12th March 2021

Application No: A/11/21/HH
Site Address: Waterton House Arundel Road Angmering BN16 4JR
Description of works: Minor exterior and interior alterations to Listed property including 3 x new windows, back elevation, demolition of an interior dividing wall & other minor works. This application affect the character & appearance of the Angmering Conservation Area.

Thank you for your internet representation made on 11th March 2021 which has been recorded as no objection with the comments as follows:

NEW WINDOWS REF W3

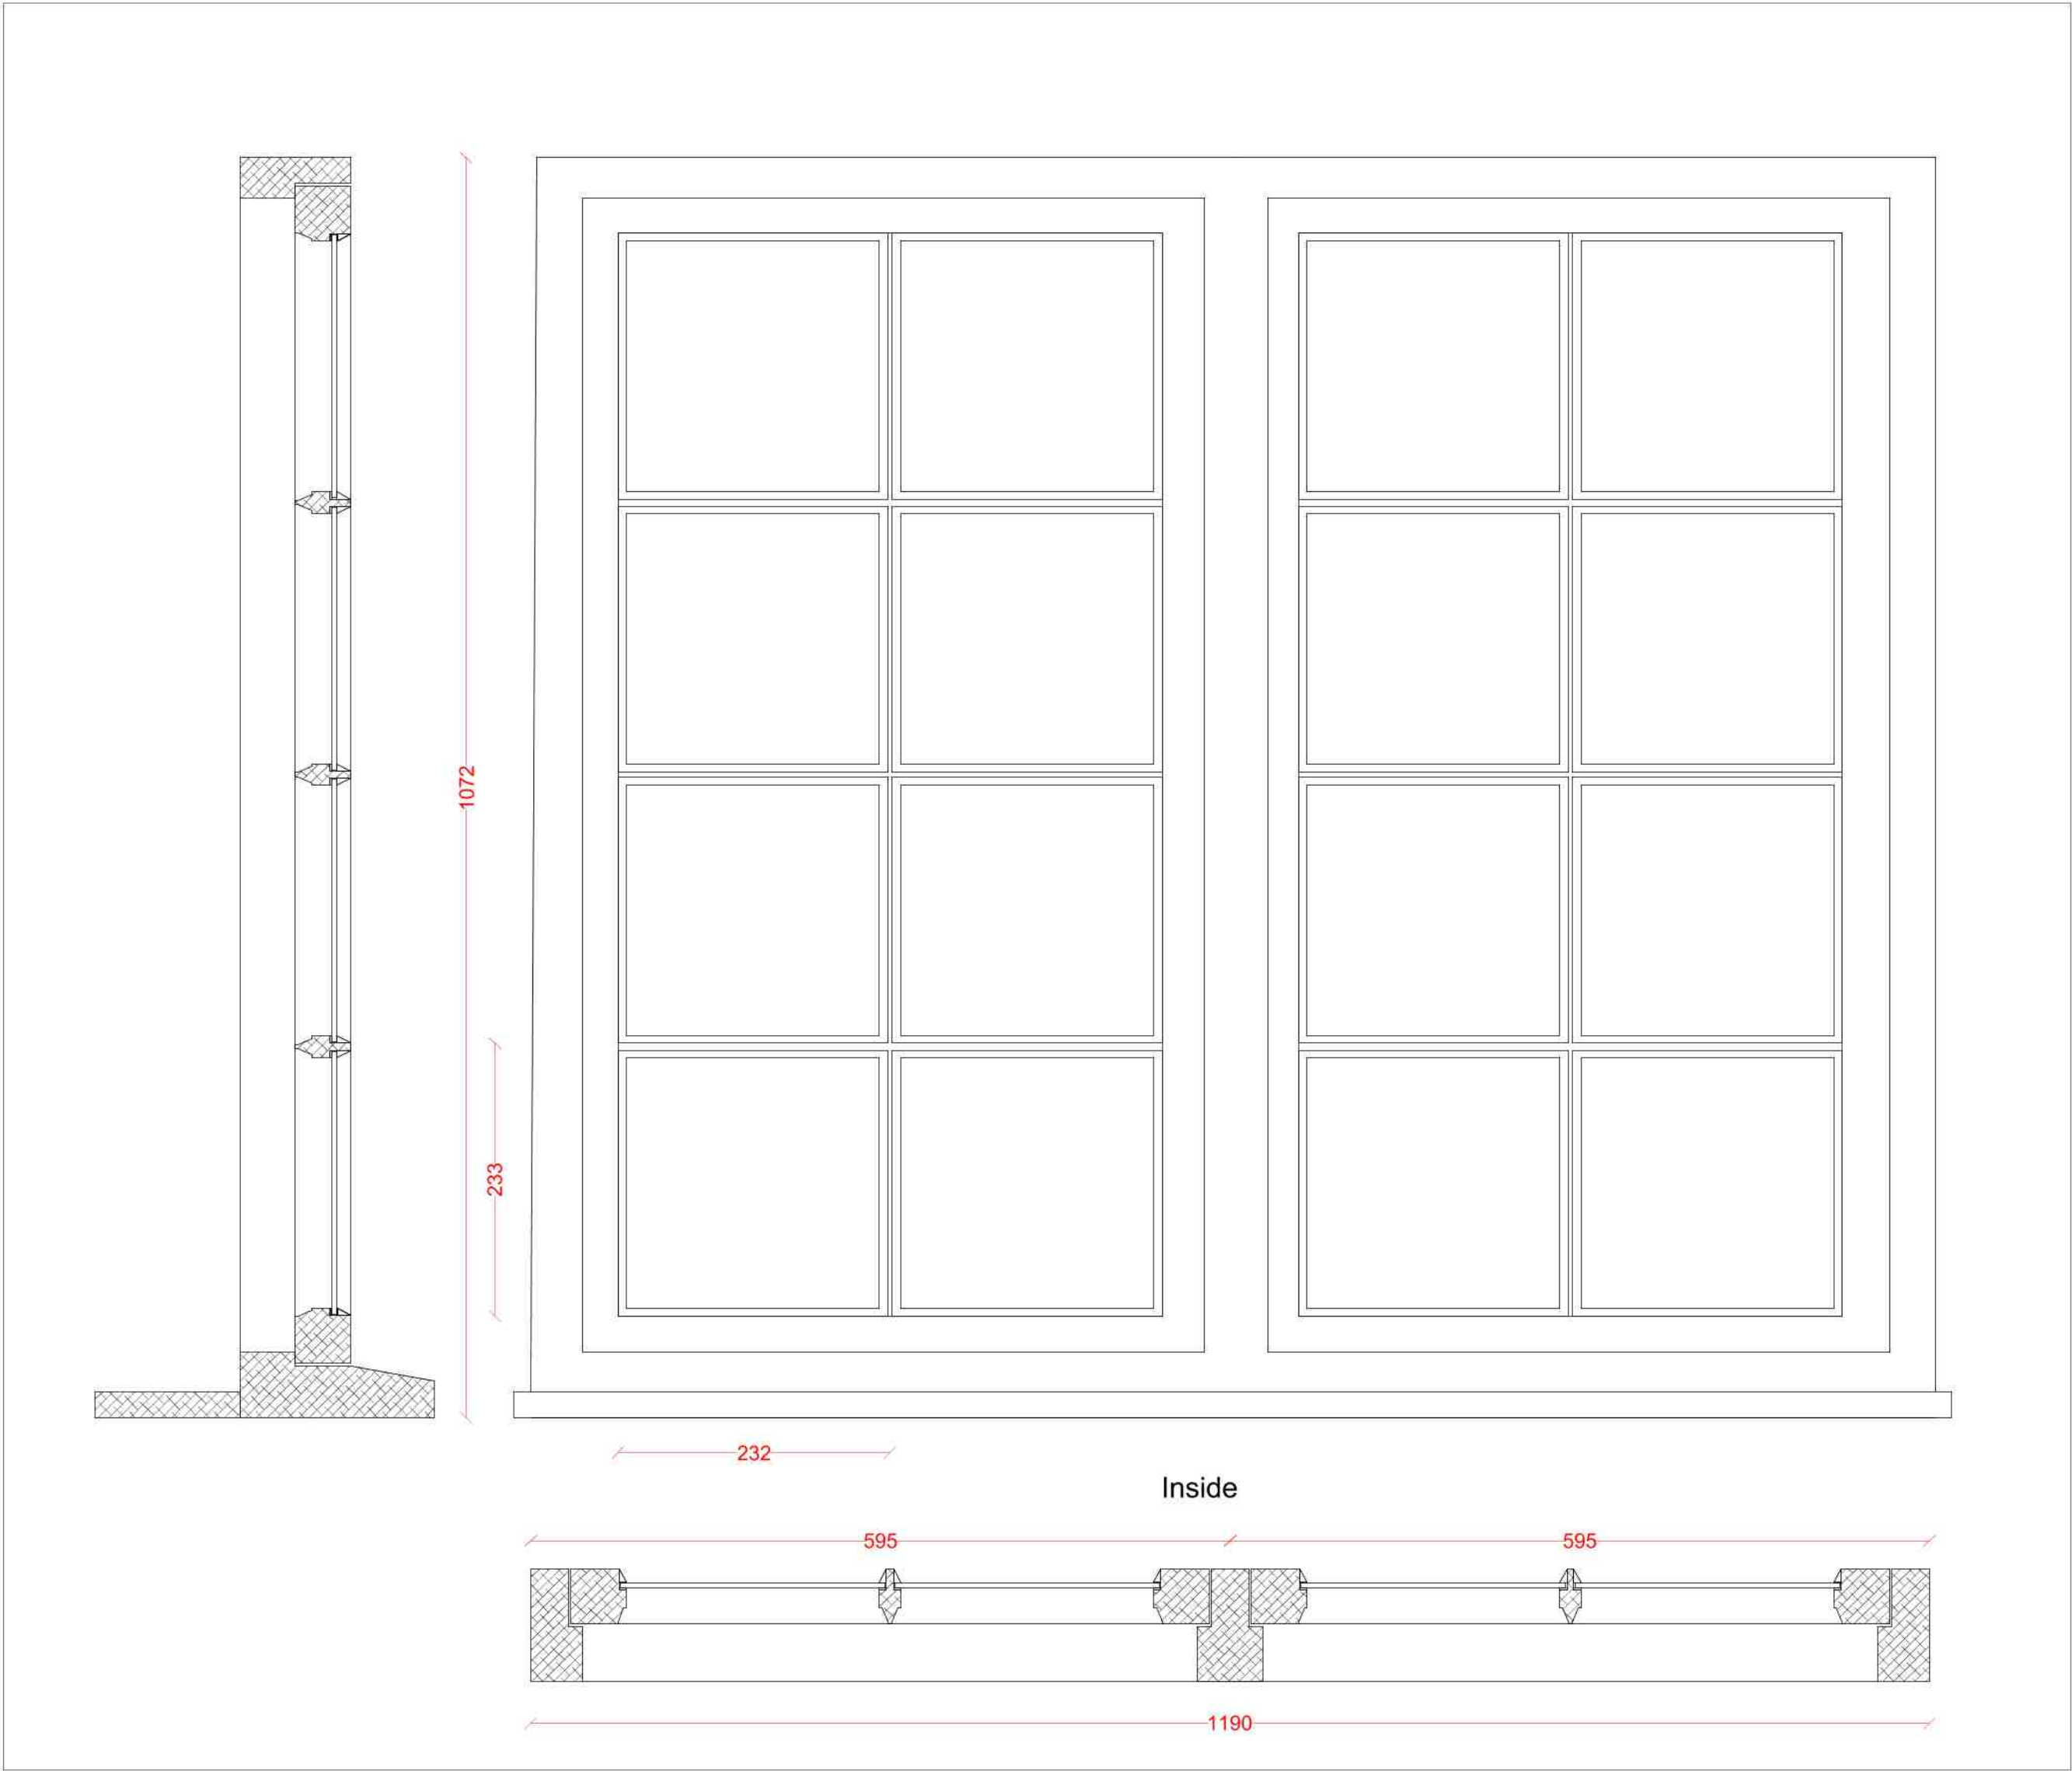
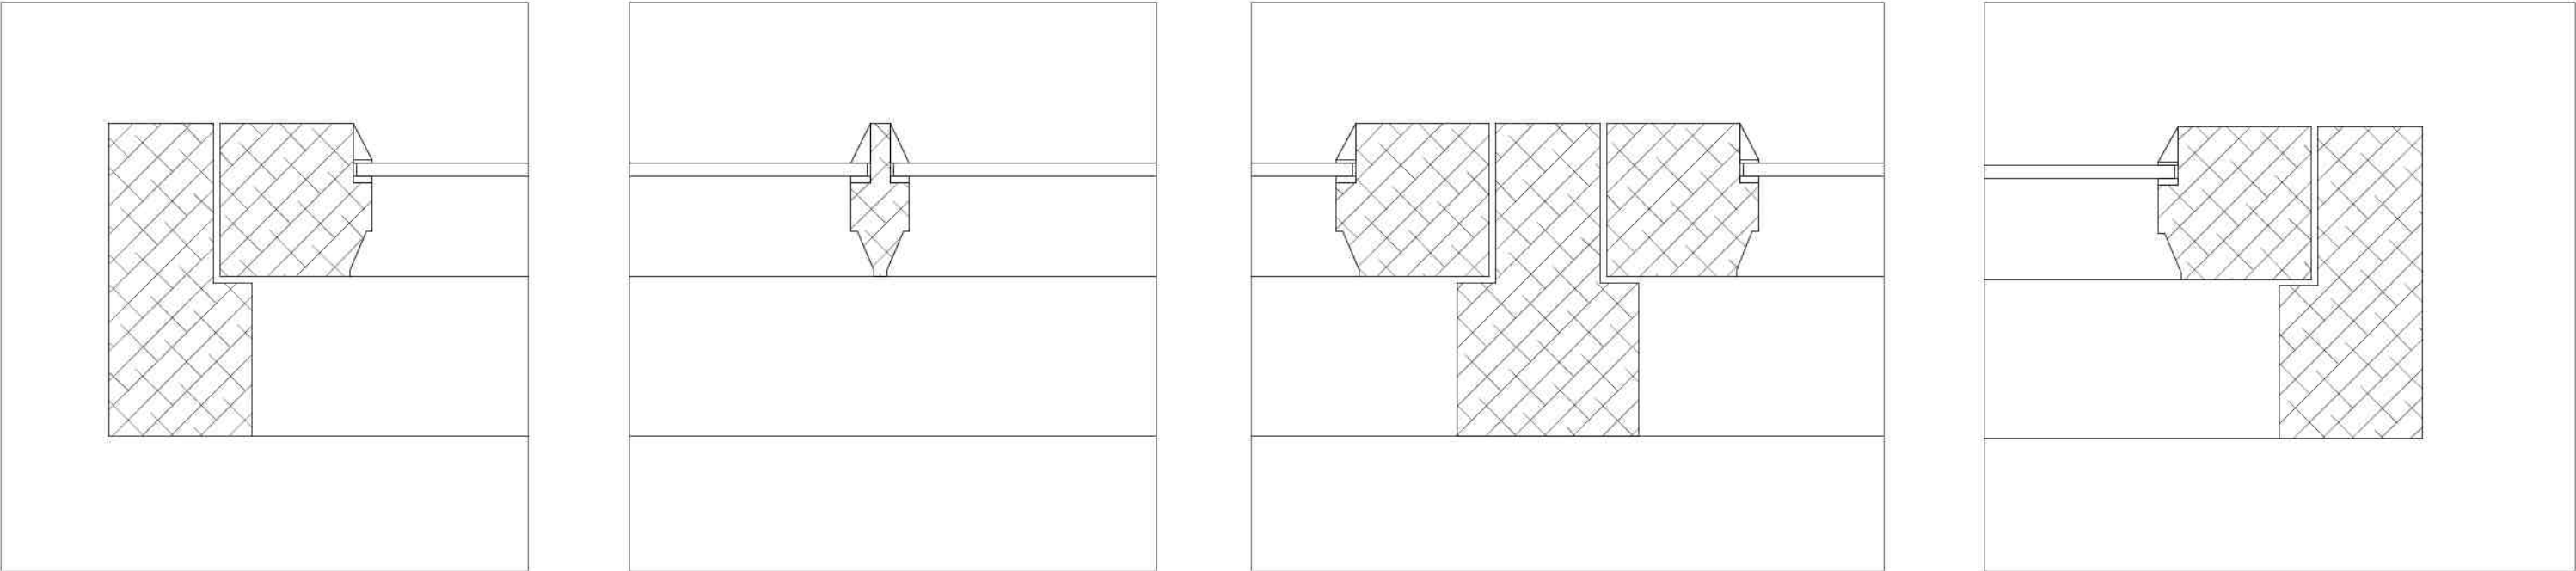
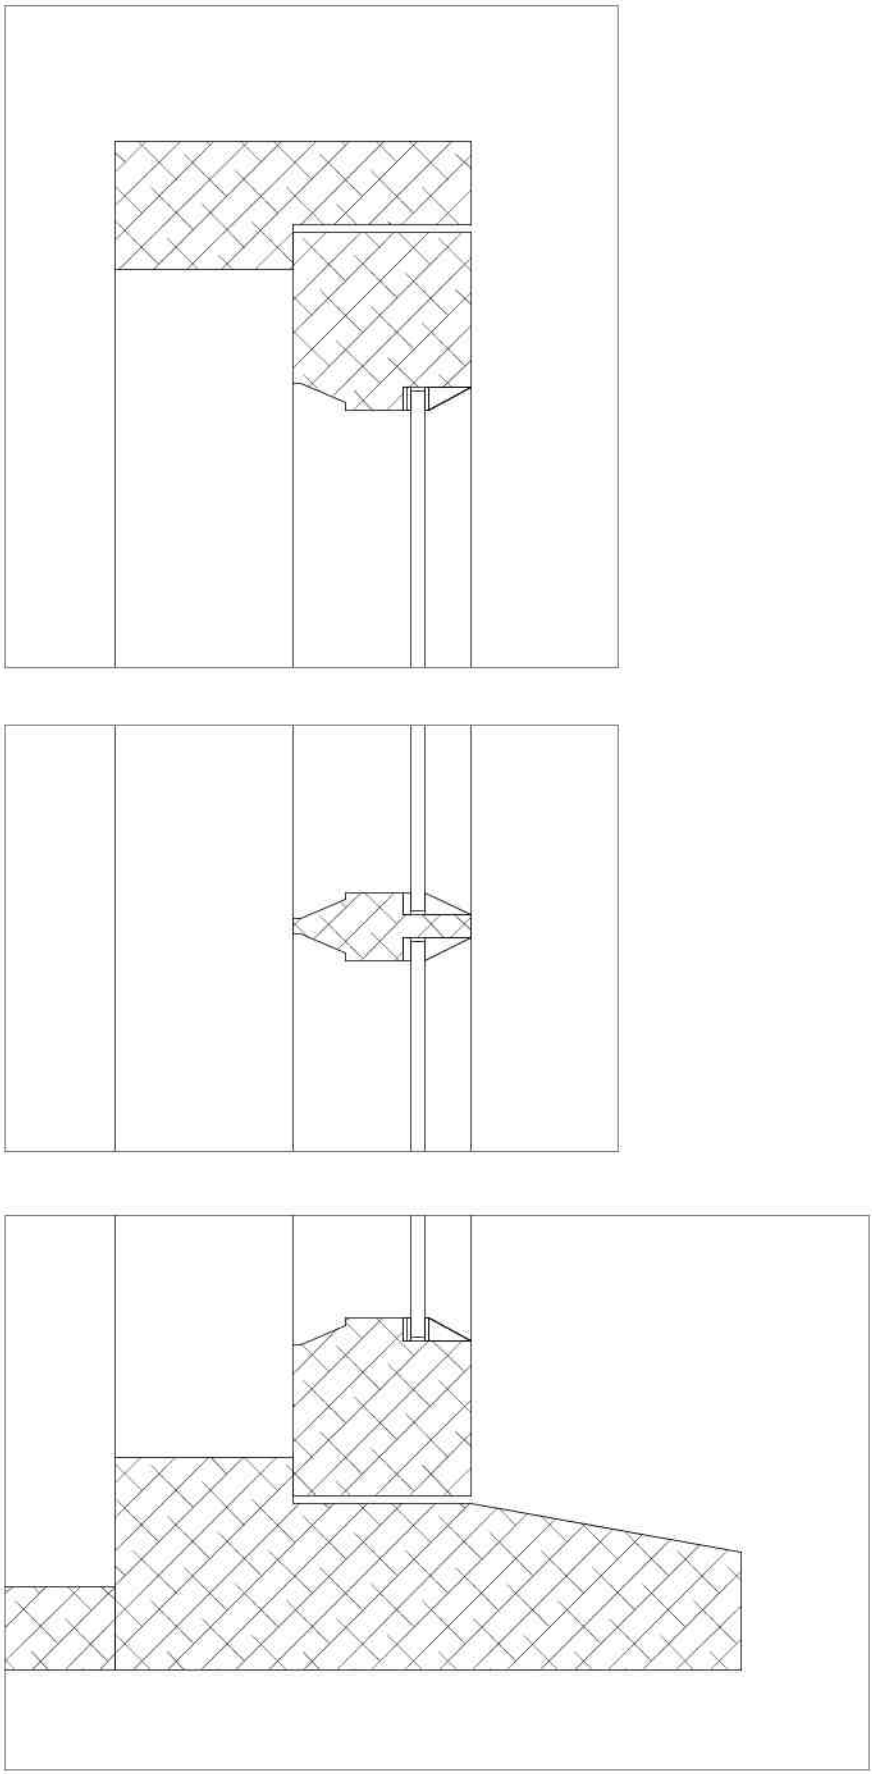
Would like the windows to be wooden
